From: Kathryn [REDACTED]
Sent: 14 February 2019 09:16
To: Andrew Wood
Subject: Re: LU/5/19/PL - External Materials

LU/5/19/PL – External Materials

PROPOSED ELEVATIONS
1:100

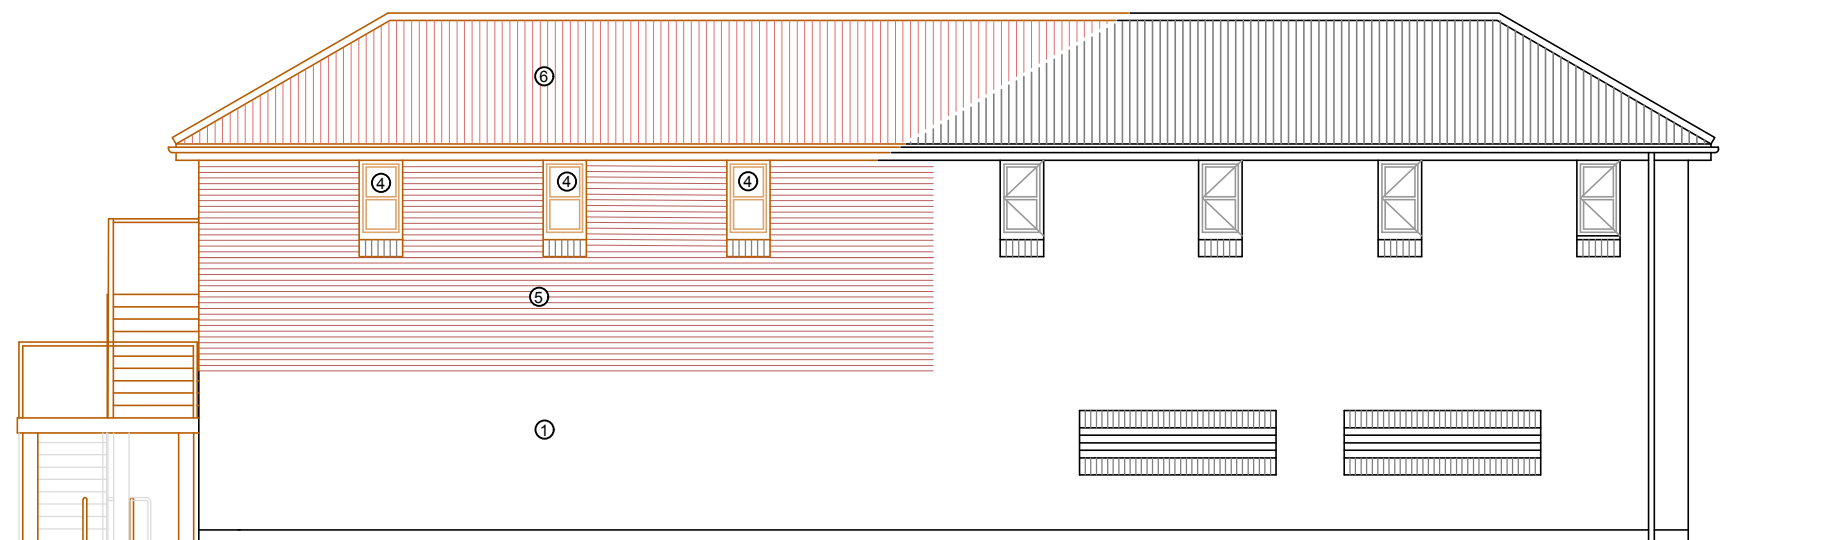
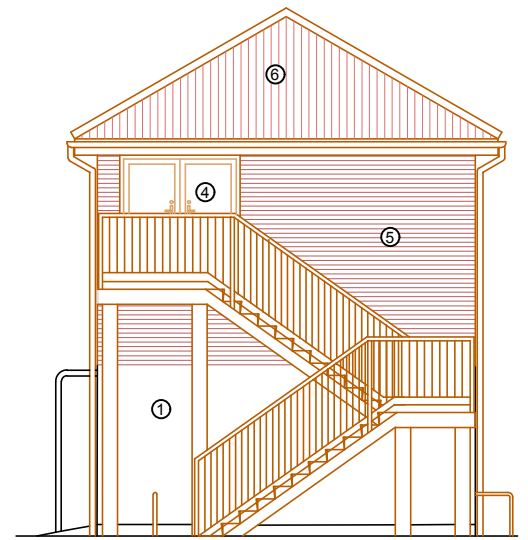
- 1) The Council has made a considerable investment in the appearance of the area including the river path and walkway and beachfront improvements in recent years.
- 2) The appearance of the building will have a significant visual impact in winter and a lesser impact in Summer on the Oyster Pond Park. The building in no way reflects the character of the surrounding area within a theme park and is currently contrary to design and tourism policies
- 3) Whilst I appreciate you will attempt to use matching materials the likelihood is that the external appearance of the building will be staggered where the new materials join the old materials such that a re-surfacing of the elevations of the building would be a significant improvement in what has been proposed.

Can we agree materials for the external wall surfacing either a blue /light blue ‘marine’ coloured render or weatherboards to match the other out buildings within the theme park ?

I can then formulate an appropriate condition that gives a medium term time period for the final re-surfacing of the walls of the building to be carried out. The roof materials could approved to match existing as a compromise.

Whilst I agree that initially the proposed extension will look new, we are of the mind that due to the harsh weather conditions it won't be long before the old and new merge into one. Saying that the difference between old and new would be very apparent if we were to go a different route with the treatment of the external finishes, which is why we are strongly resisting this. A condition with time limits to alter the exterior of the existing building would also be resisted. The management and maintenance of the site has to be at the discretion of my Clients which are solely lead by the business needs and its limitations at any time. We feel that trying to retrospectively gain control over an existing building a little unfair, Arun DC granted permission for the look, size and style of the building under its historical guidance. The extension to the building could ultimately look like monstrous miss match if we were to take a different approach to its styling.

In conclusion, we hope that you are minded to approve the application such as it is. We originally chose to extend the building with similar materials thinking it was by far the most logical, practice route to take. The ongoing success of the park is my Clients most obvious aim, with the success of the park comes a boost to the positive momentum of the area as a whole.
